Consultation Response from: KC Environmental Health (Pollution & Noise Control)

2023/91454 Helm Farm, Colnebridge, Bradley, Huddersfield, HD5 0PU

Conversion/demolition and restoration of former agricultural building to form 5 dwellings erection of new garages to serve plots 2-4 and extension to plot 5

Responding Date:
2nd August 2023

Proposed Site Layout

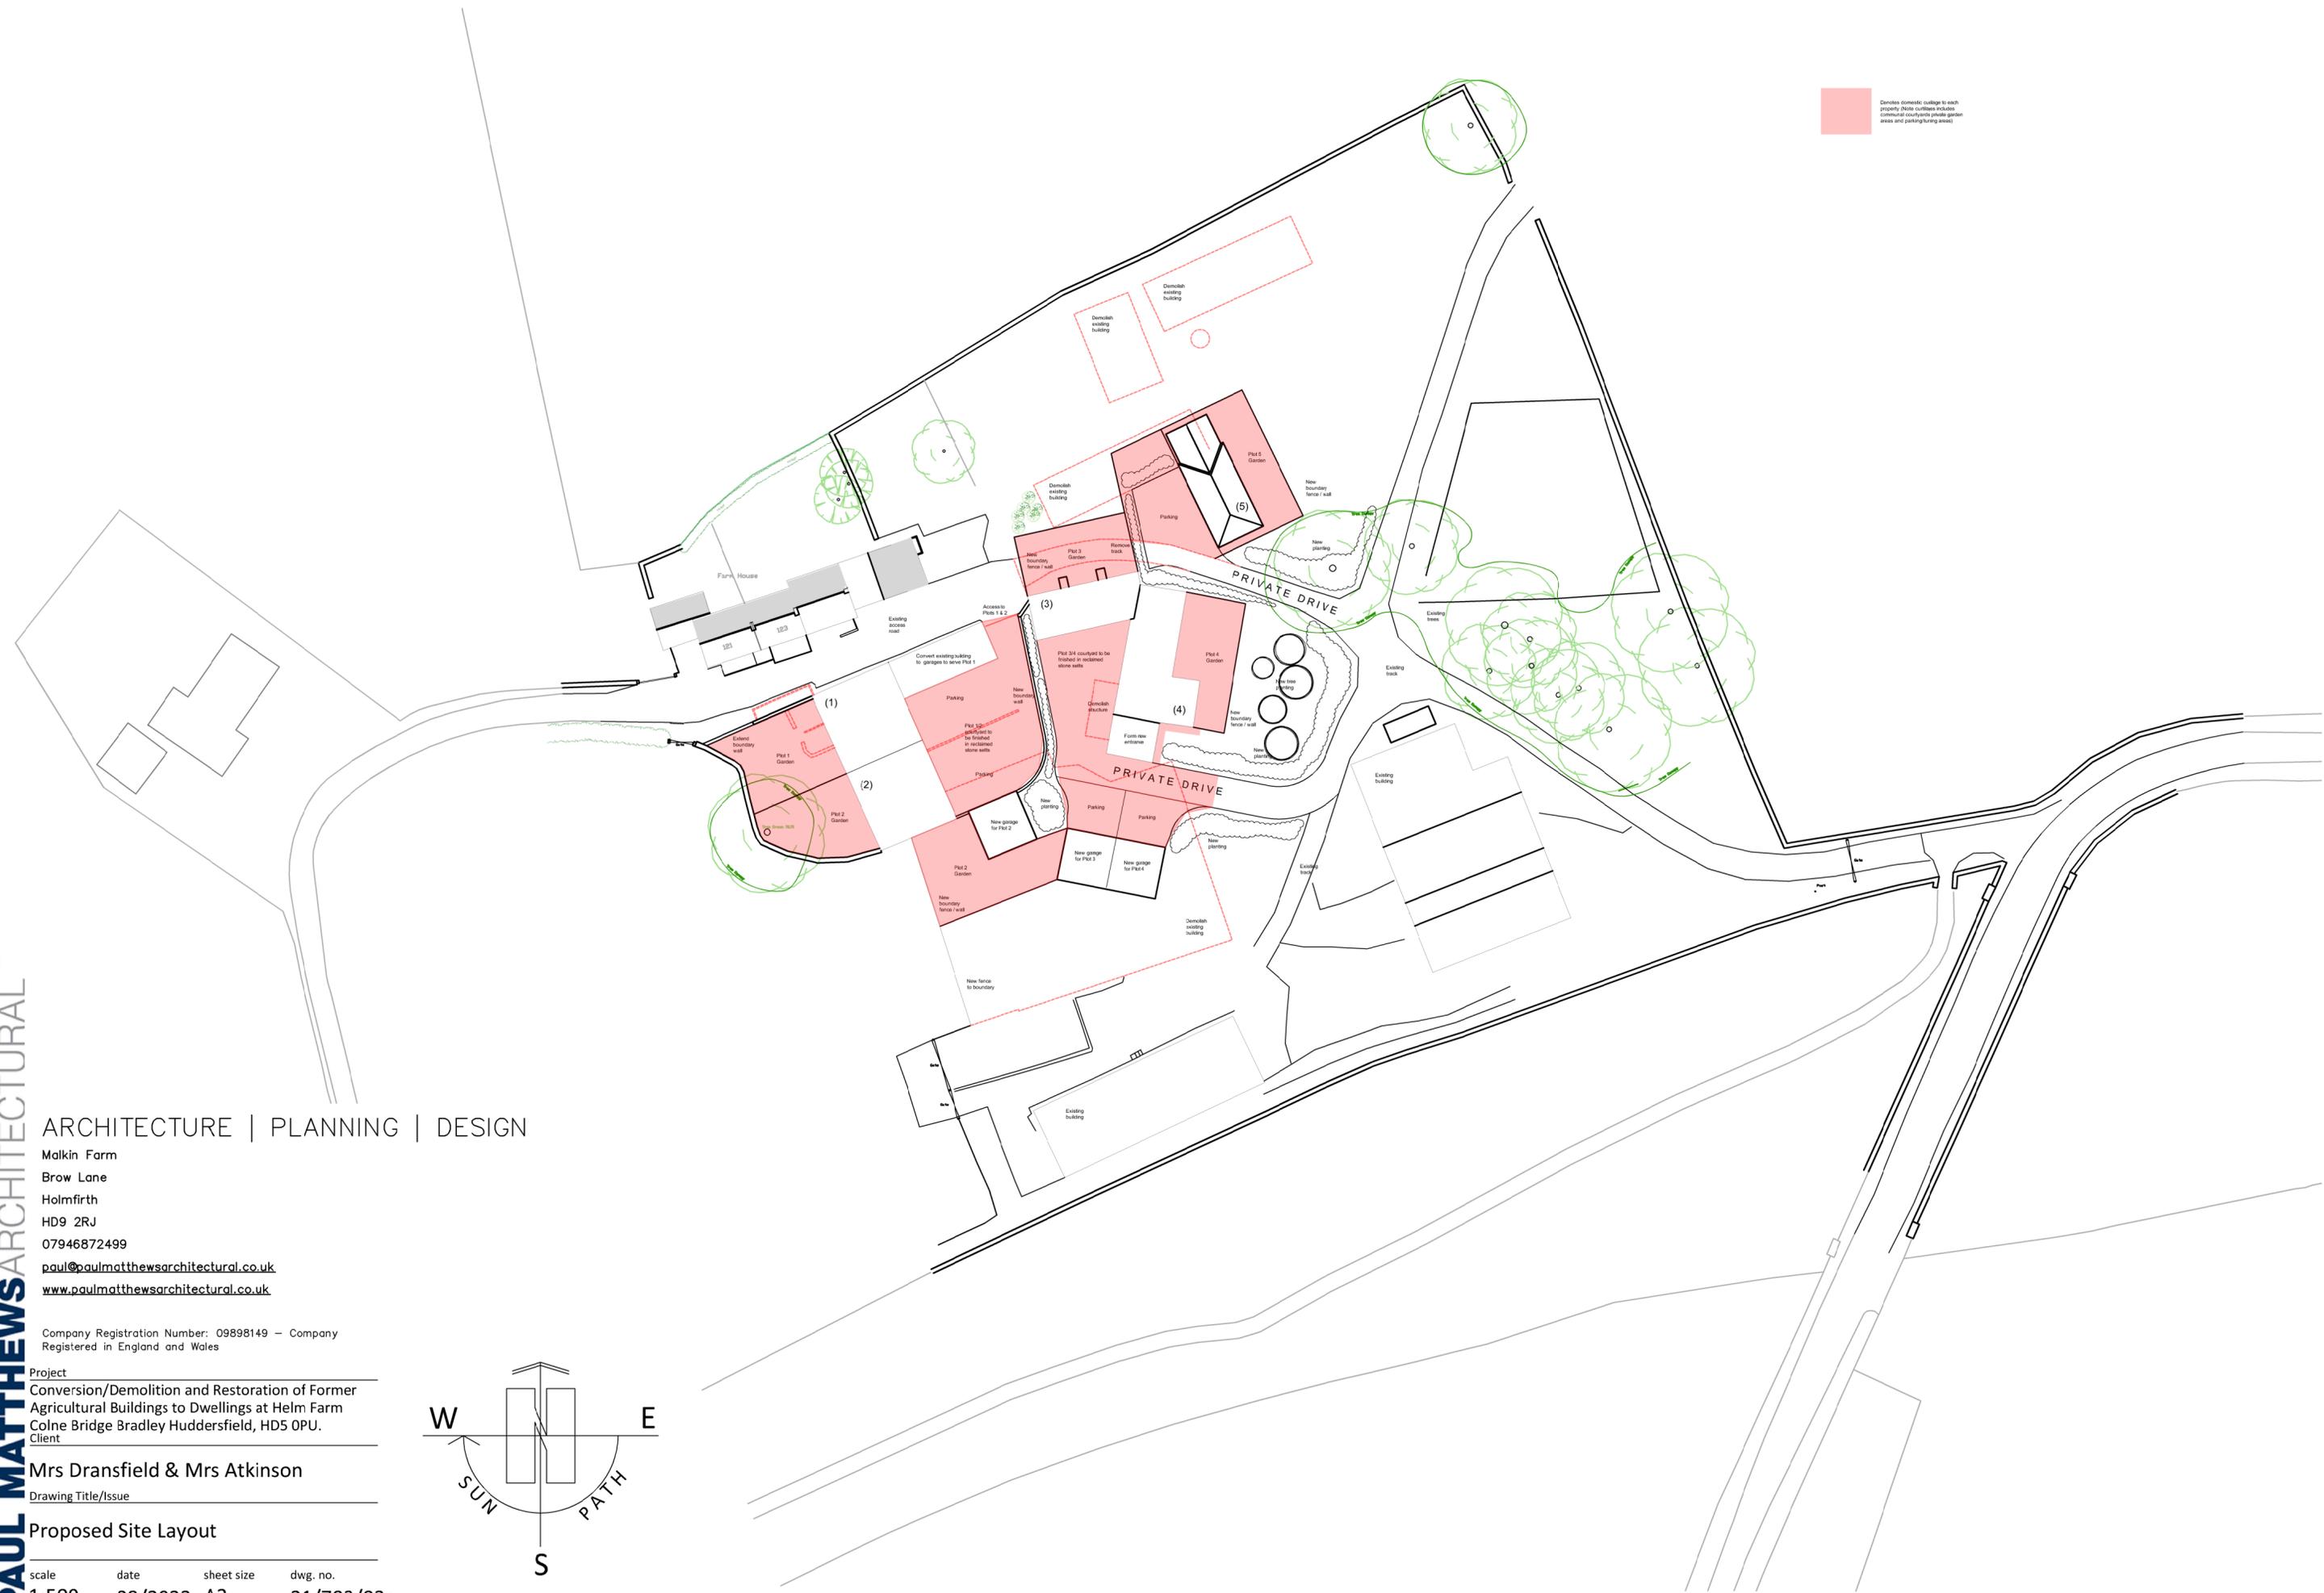
A plan by Paul Matthews Architects, titled proposed site layout, dated 9/2022, drawing no 21/703/03d has been submitted, this informs us that each new dwelling will be provided with a package treatment plant sufficient for 12 persons and each will be positioned a minimum of 8m away from each dwelling.

We accept this information but would remind the applicant specialist advice should be sought for the design and installation of sewage treatment systems which should meet the relevant standards. The conditions relate to Planning Control only. Approval under the Building Regulations may also be required, and the applicant should contact their Building Control Provider for further information. Any other necessary consent must be obtained from the appropriate authority.
